Please ask for: Ms Iqraa Malik
Email: iqraa.malik@terraquest.co.uk
Telephone: 01212341390
Our Ref: FG/89/21/HH
Your Ref:
Date: 19th May 2021

Application for Planning Permission for Works or Extension to a Dwelling

Development: Rear extension including pitched roof alterations,
Extension of existing side dormer with flat roof.
Extension of front entrance to hallway with pitched roof and gable to side.
Location: 25 Ocean Drive Ferring BN12 5QN

25 Ocean Drive, Ferring - Location Plan

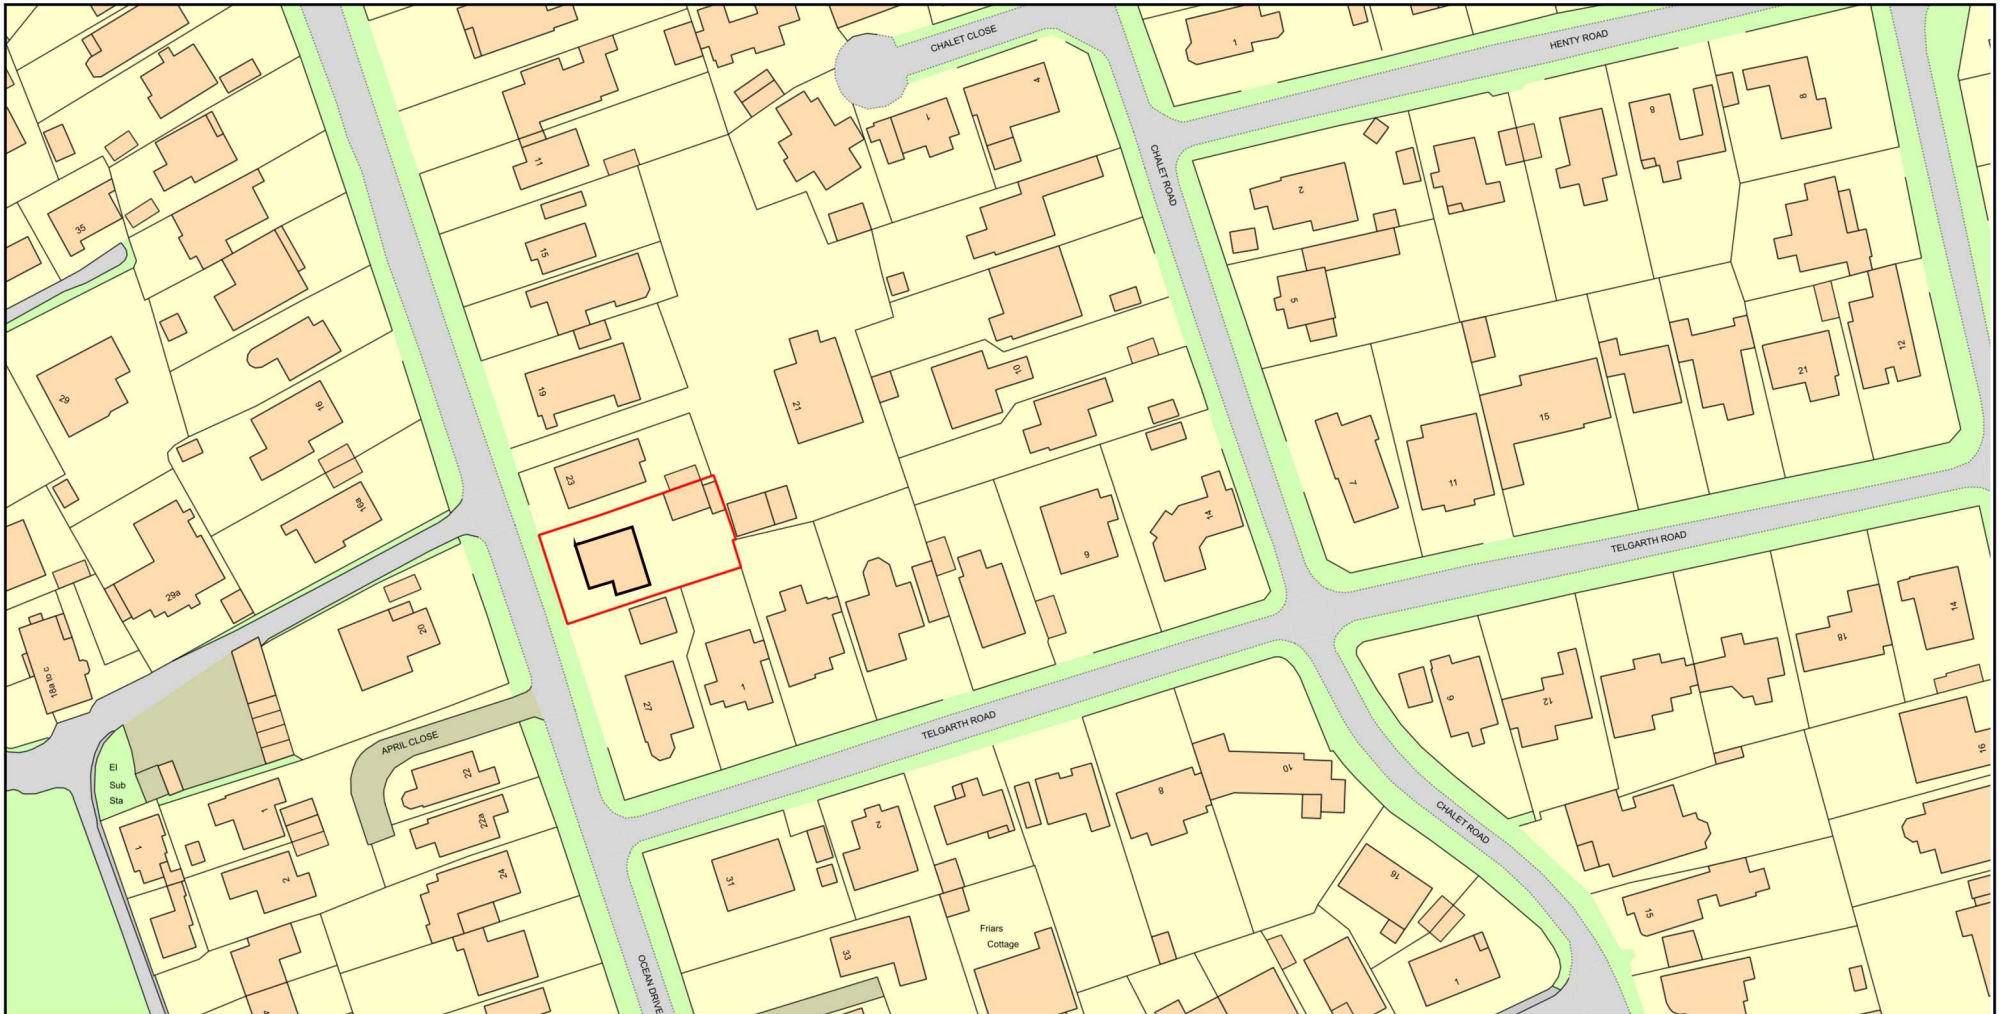
Location and Block Plan

The location and block plan require one solid red outline around the site boundary. The currently submitted plans have two outlines. Please amend.

Proposed Layout and Roof
Scale 1:50 @ A1

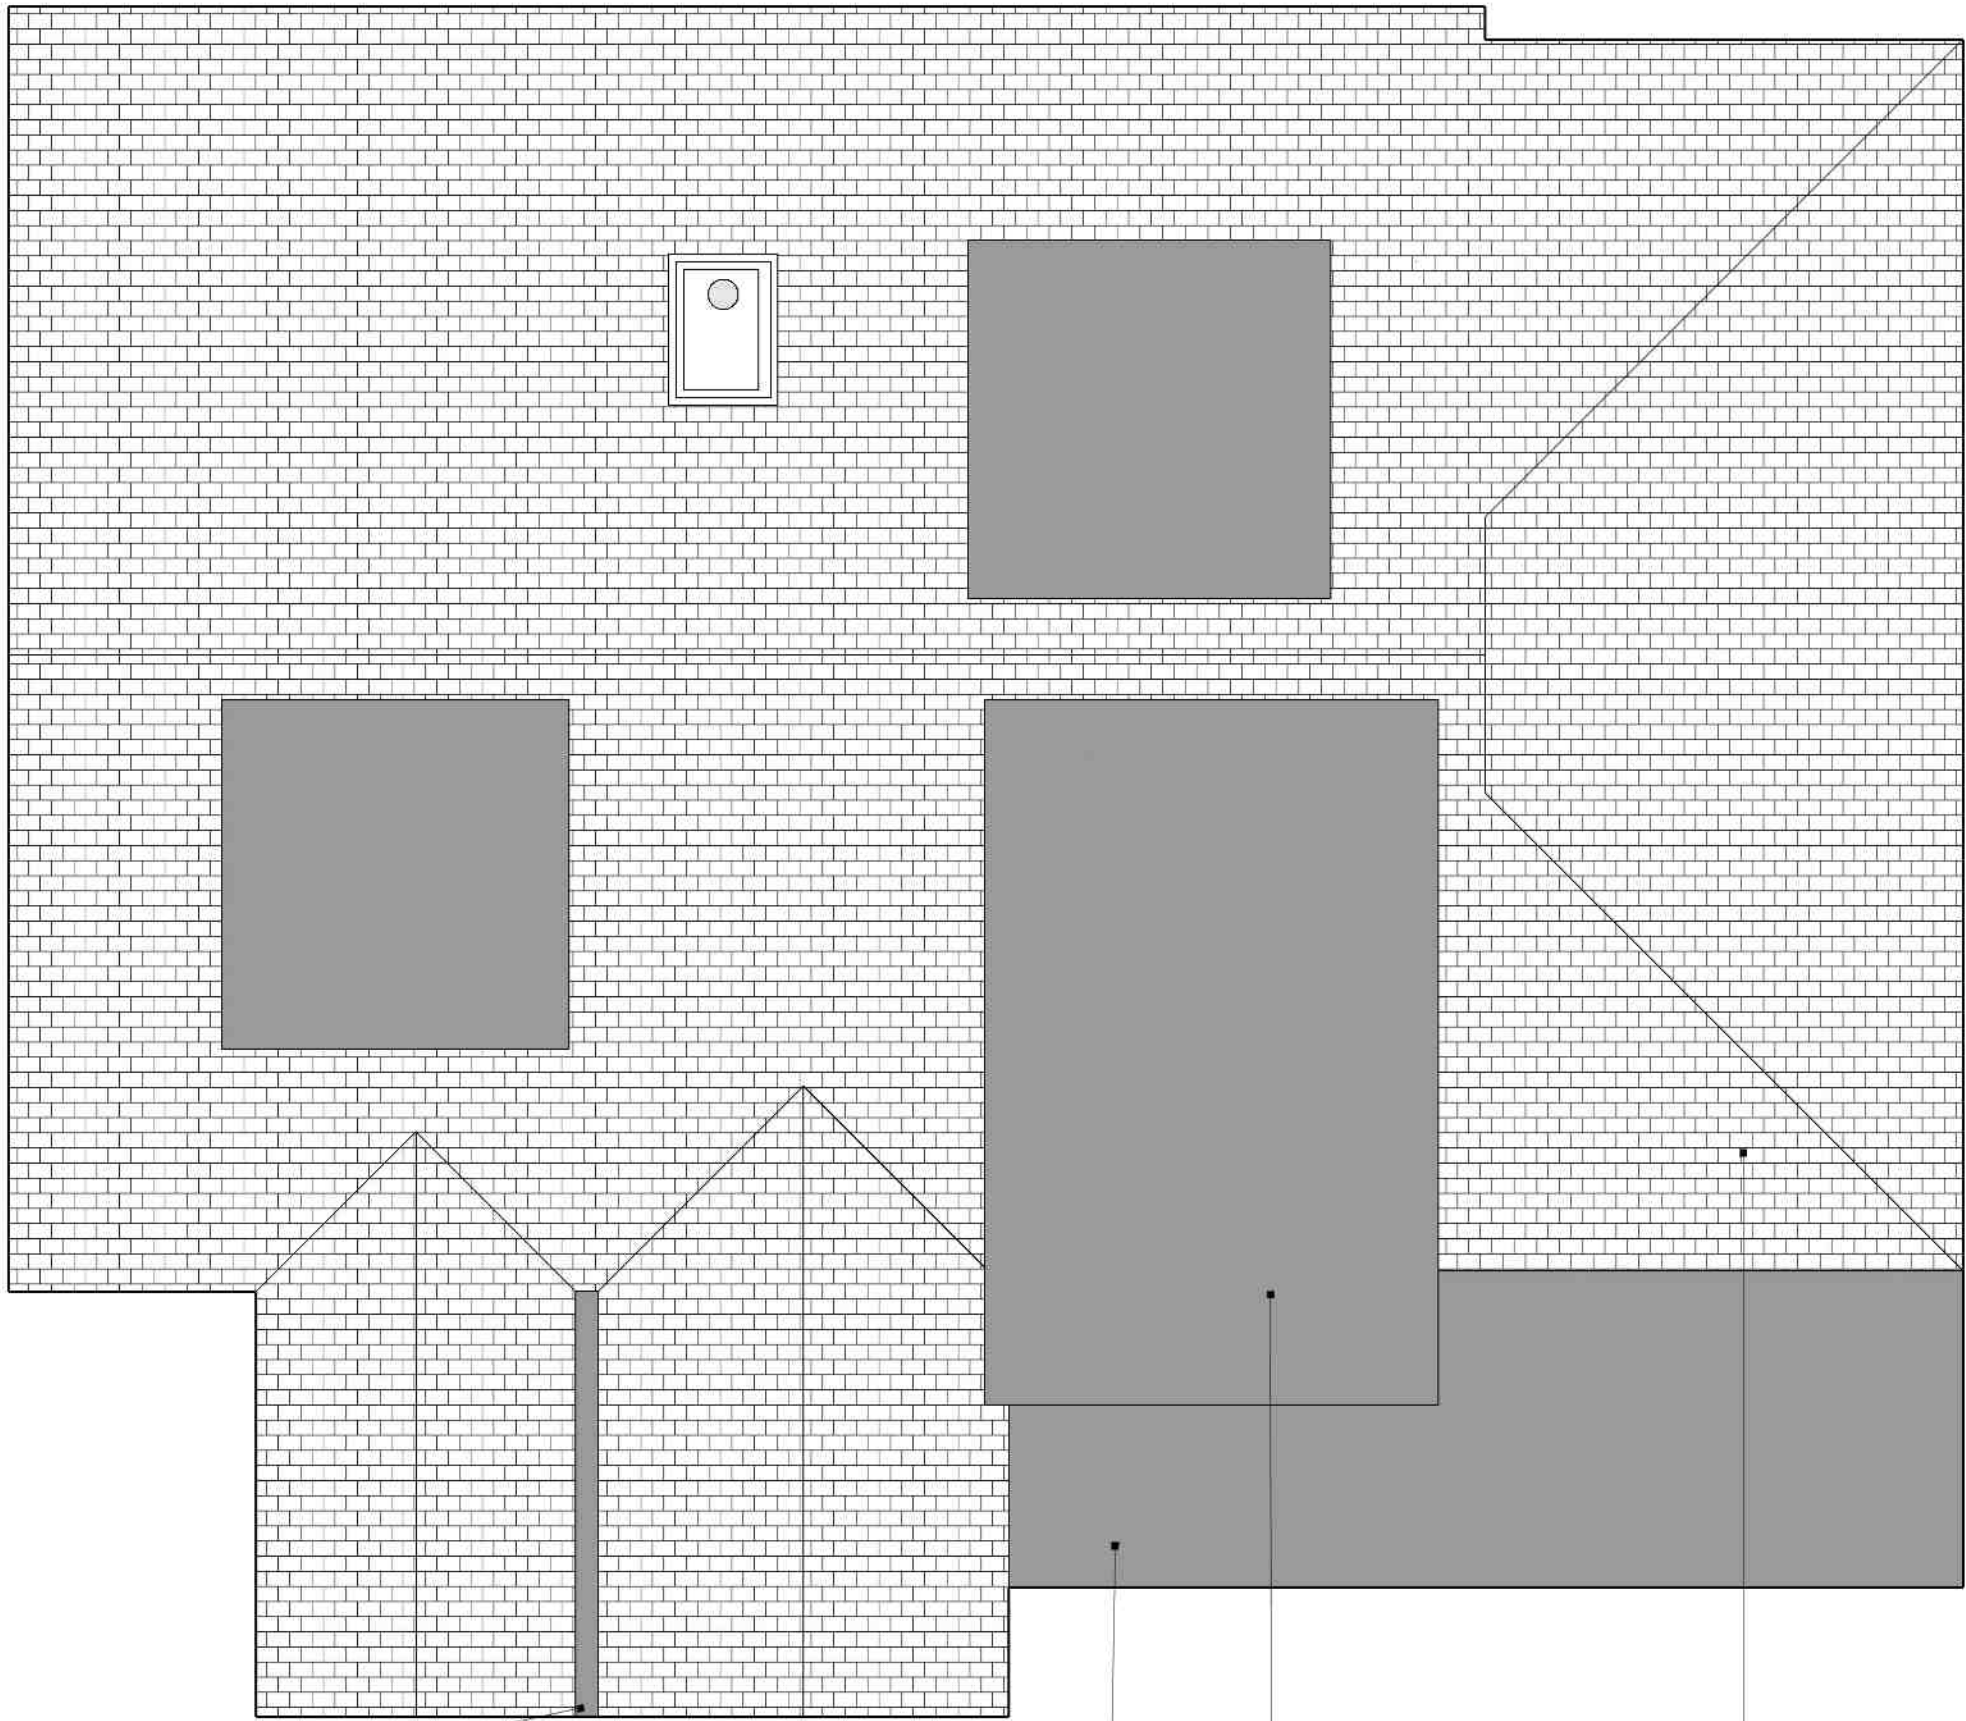
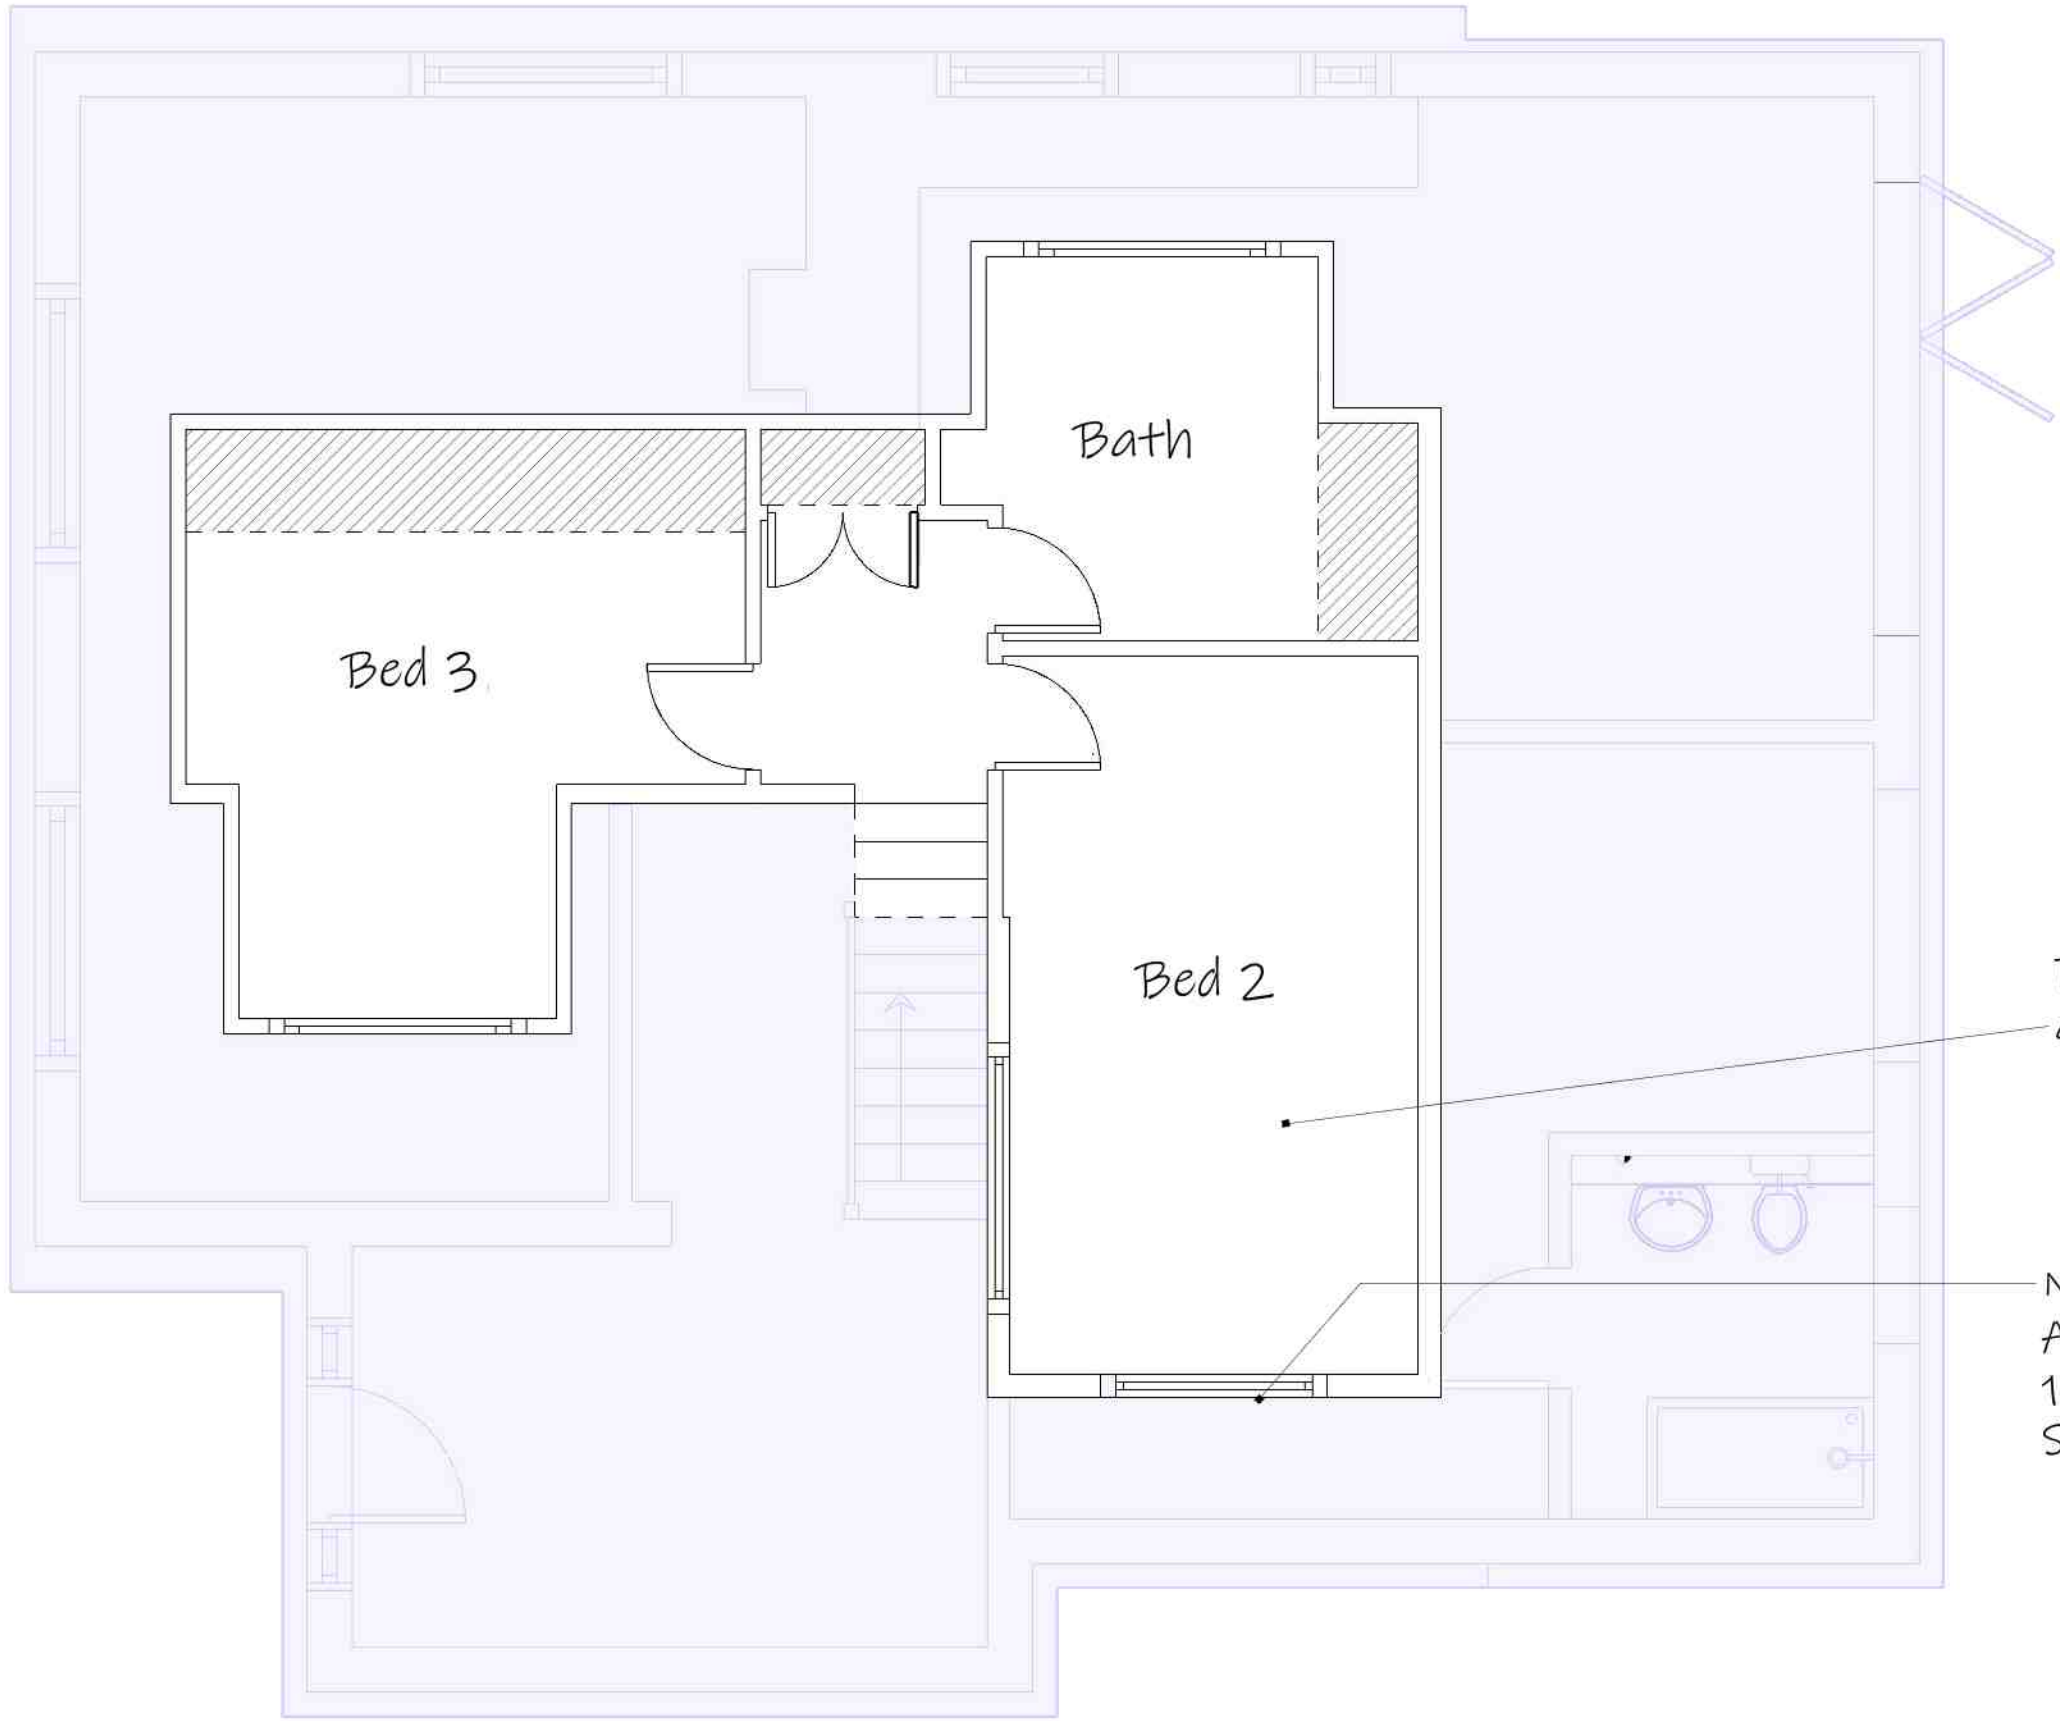
Proposed Floor Plans

Please submit a copy of clearly labelled proposed floor plans at a scale of 1:50 or 1:100. Further details can be found in the Validation Requirements List.

Room Labels

Please add room labels to all floor plans
